MERIDIAN STORAGE

LANDSCAPE PLAN

PPR2336      RESPONSE: REVISED

COUNTY FILE NUMBER:  
 PPR-2336

## LANDSCAPE PLAN

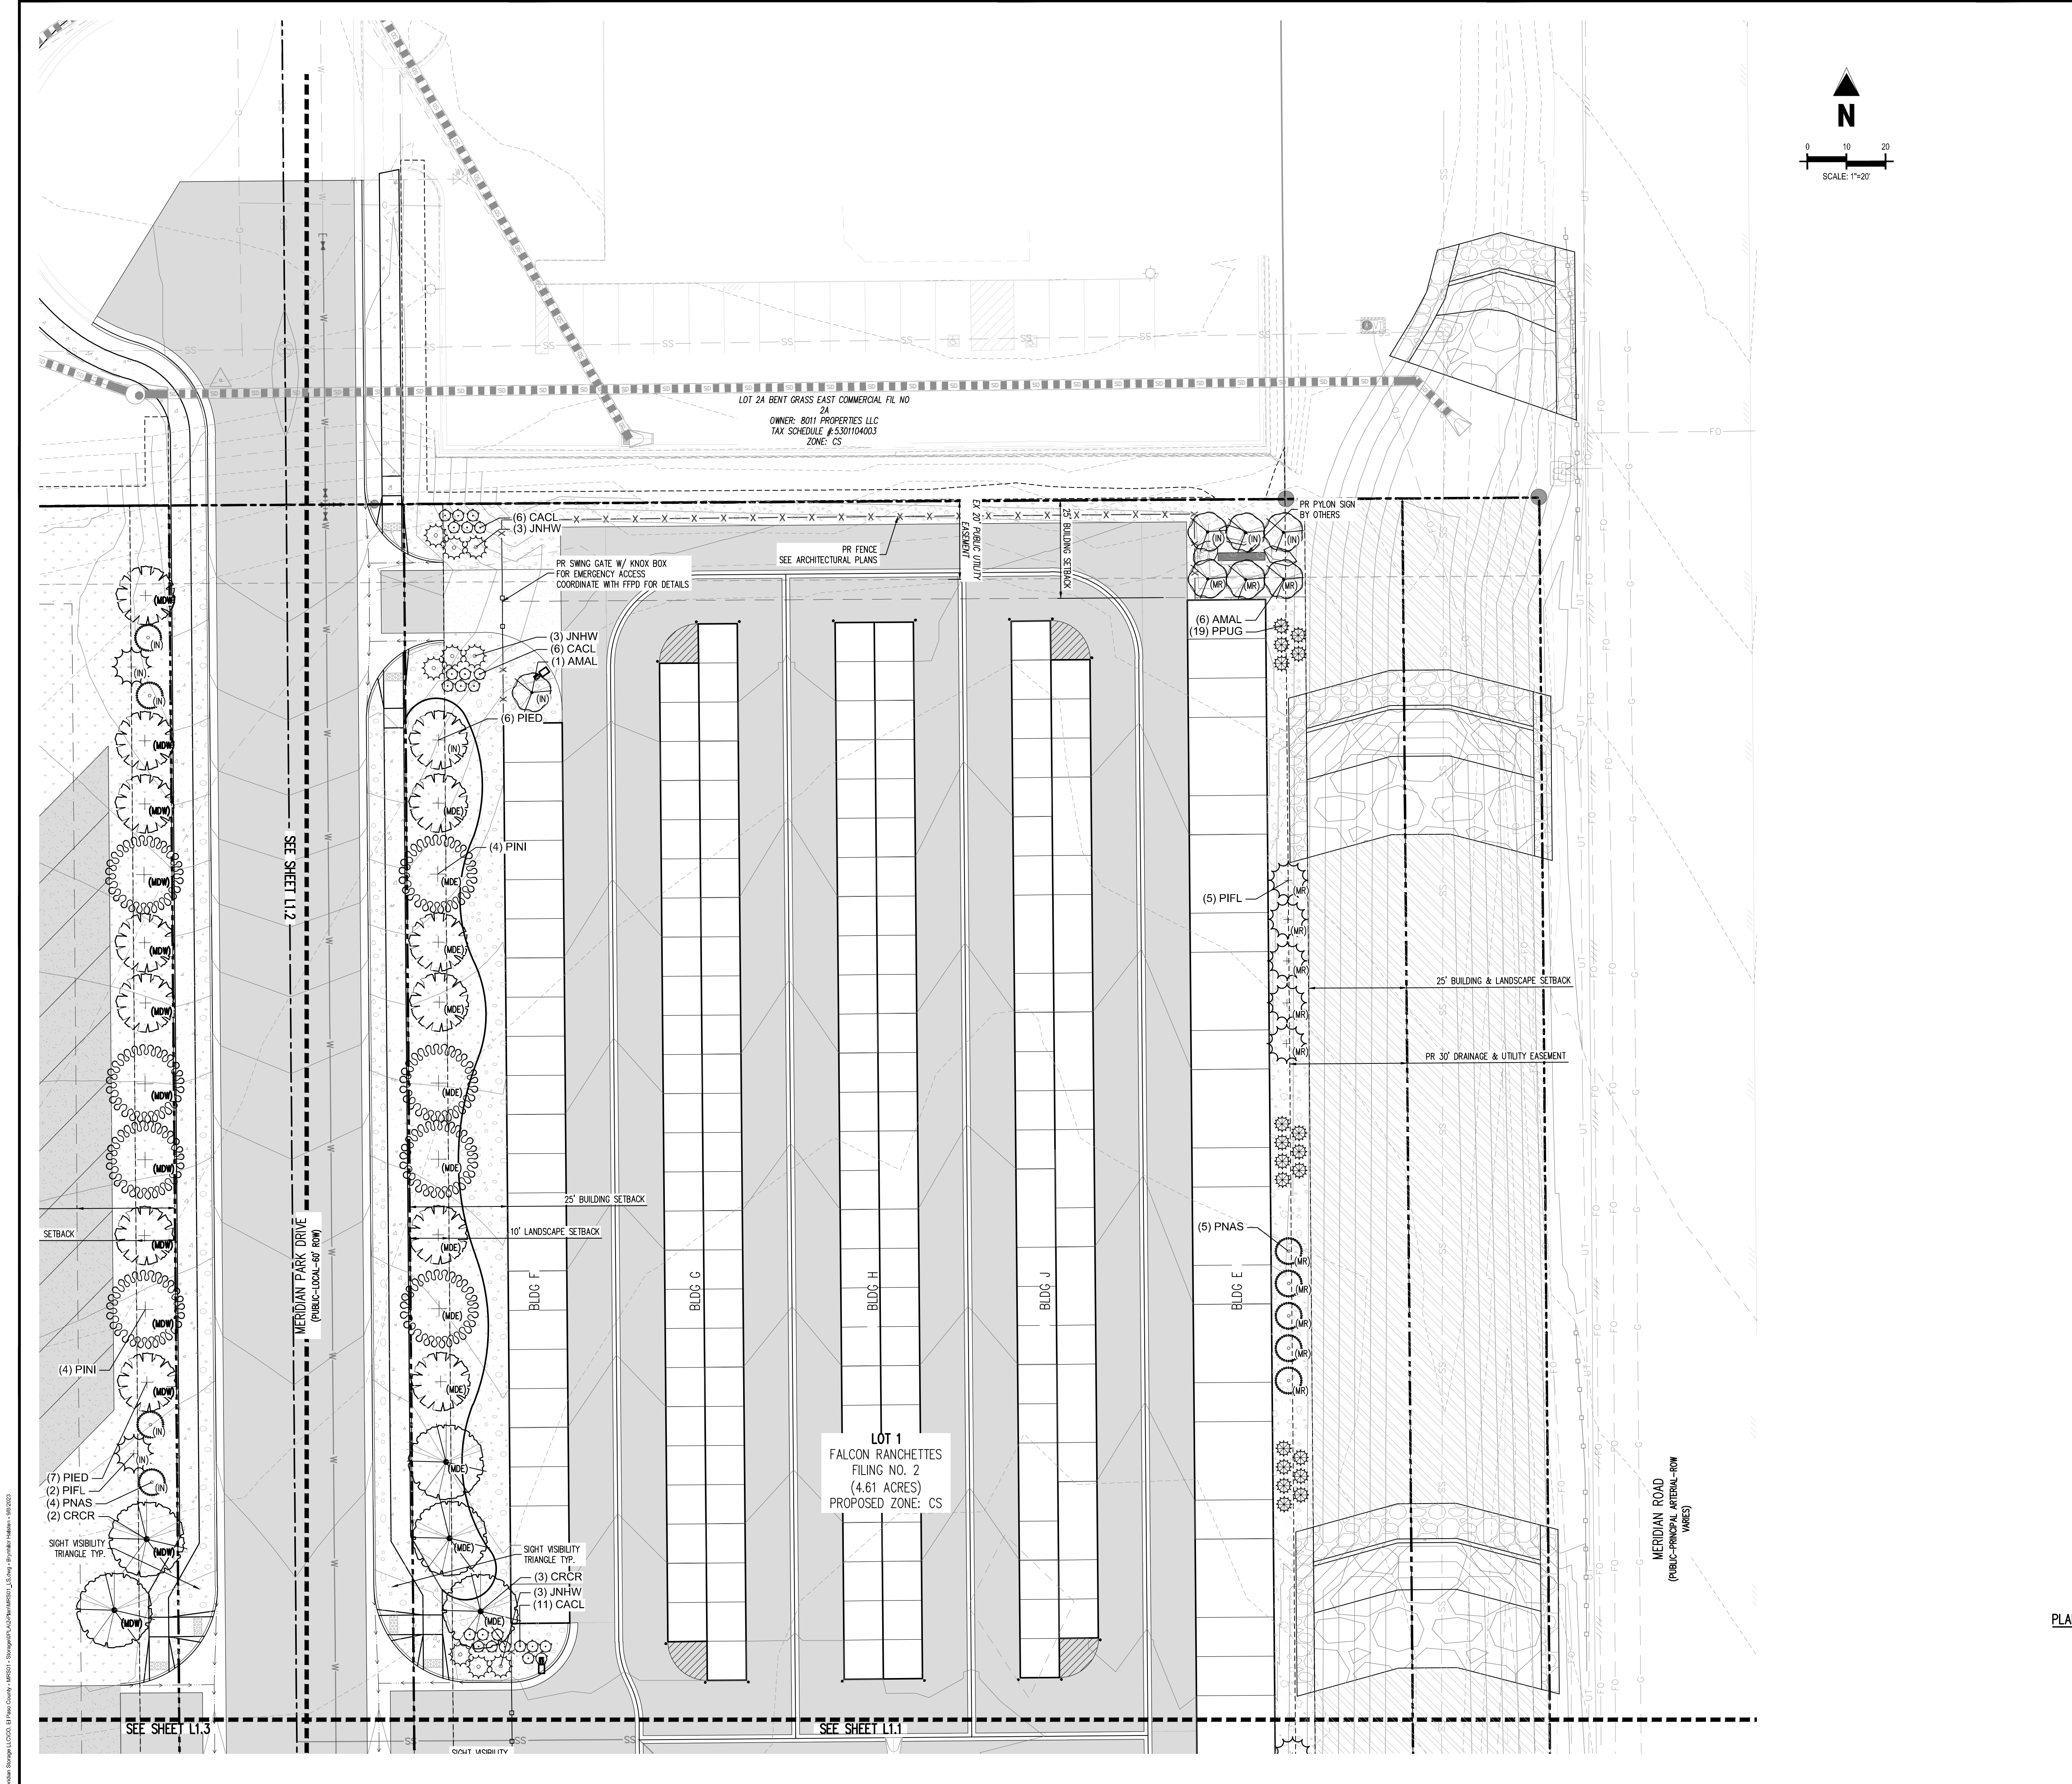
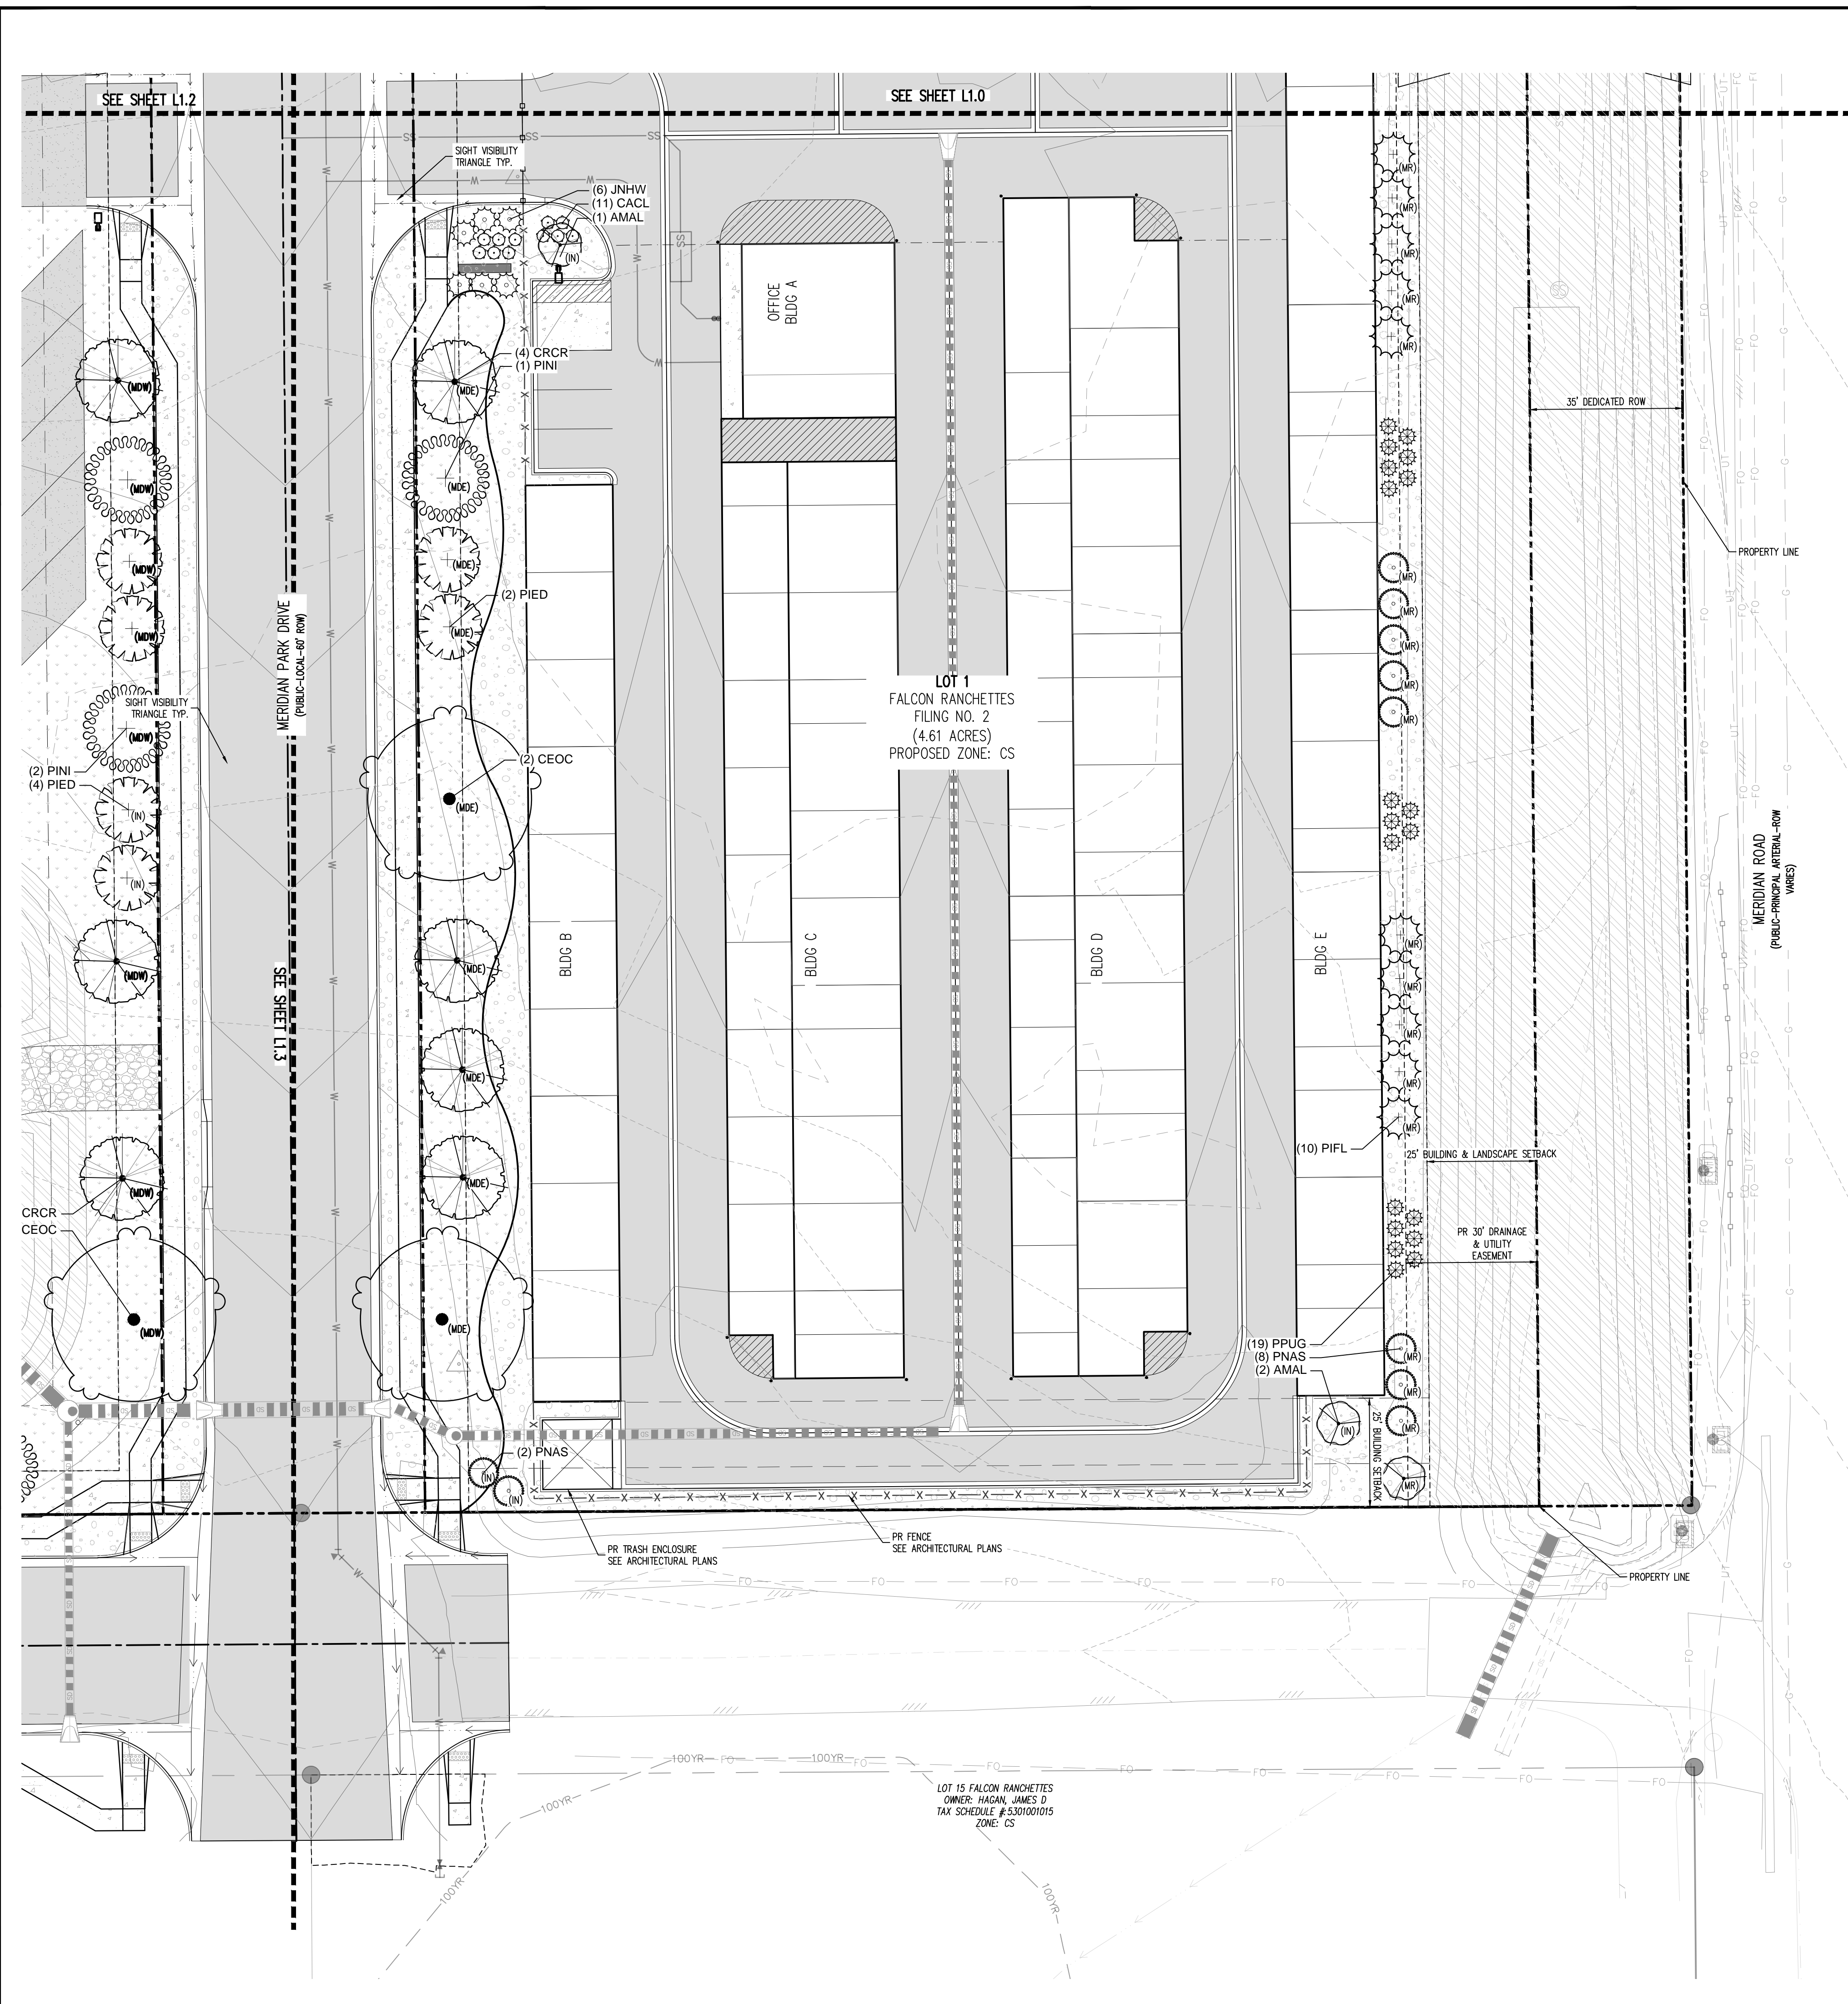
Lot 1 will still require fencing/screening per the code.

Can it be denoted where the screening/ gates will be in relation to the landscaping?  
 Can the height of the screening please be depicted as well?

RESPONSE: Lot 1 (self storage buildings) is adjacent to Commercially zoned properties and Meridian Road Right of Way. Meridian Road buffers from residential to east. No Screening required.

RESPONSE: PROPOSED EVERGREEN TREES WILL PROVIDE SCREENING
